From: Martyn White
Sent: 10 August 2018 14:37
To: Richard Castro-Parker
Subject: AB/26/18/L

I have reviewed the plans held on file, including the revisions that have been made following previous comments from the temporary conservation officer. This includes a revised hanging pub sign.

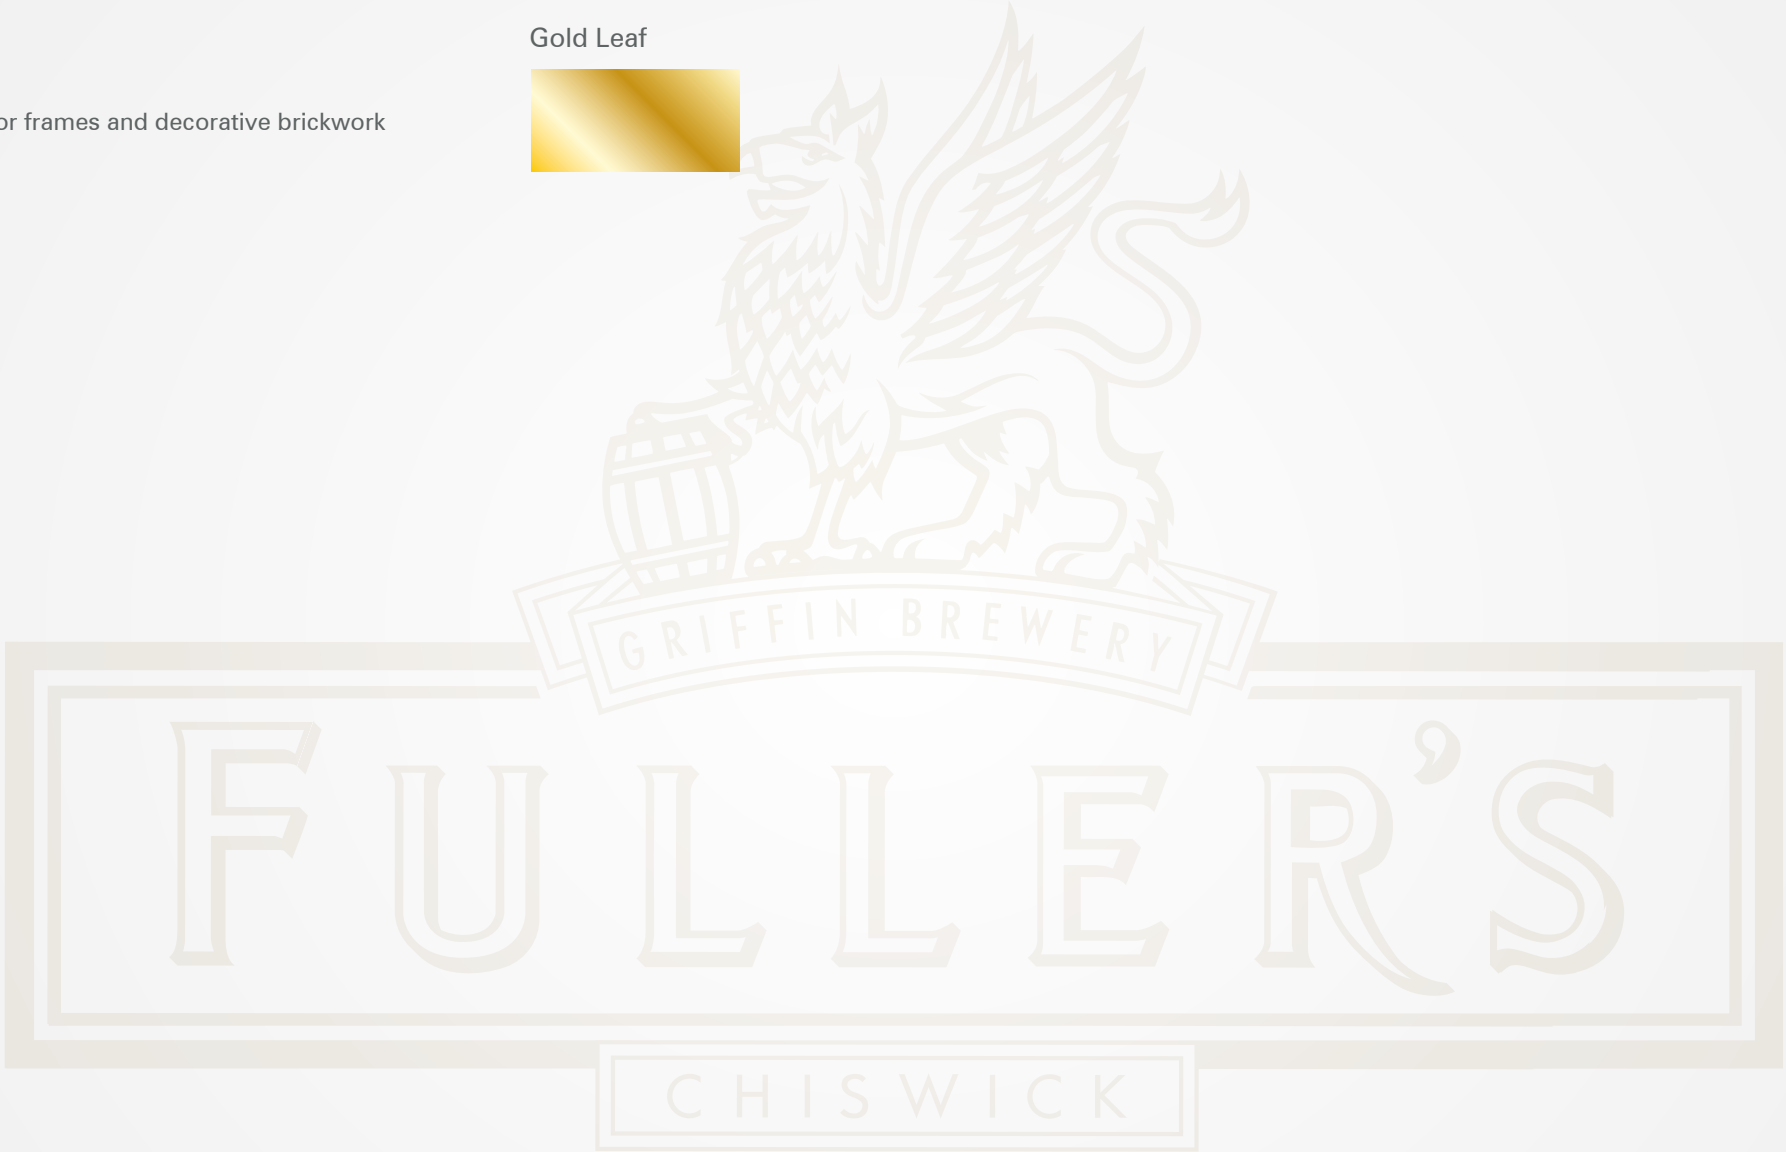
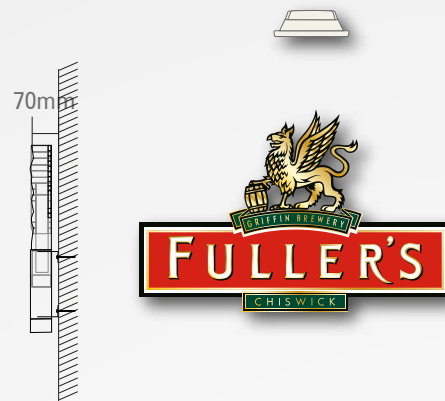
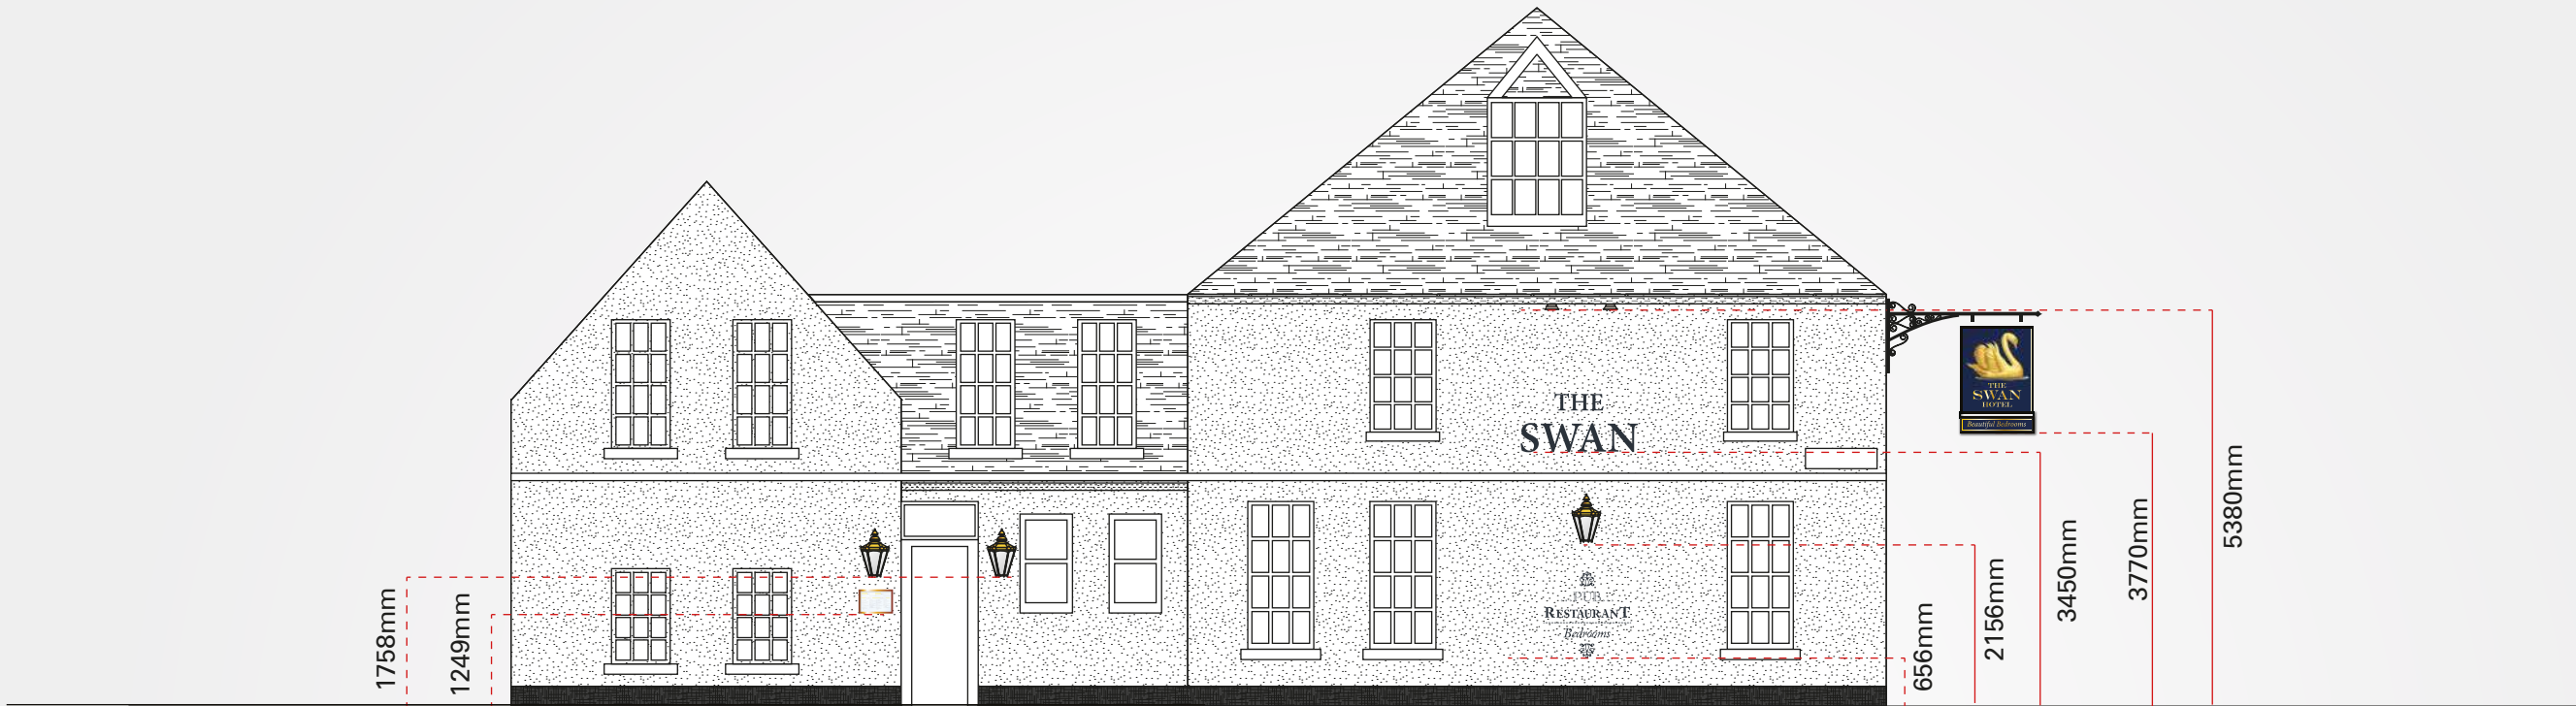
I note from a site visit that the works have been undertaken, and consider that the works as presented on the revised plans (and on the building) are acceptable.

Having reviewed the previous comments provided regarding the level of illumination, it would appear that the lighting has been implemented as requested on the plans. On balance, based on the 'night shot illustration', this appears to highlight the building, which will have a neutral impact.
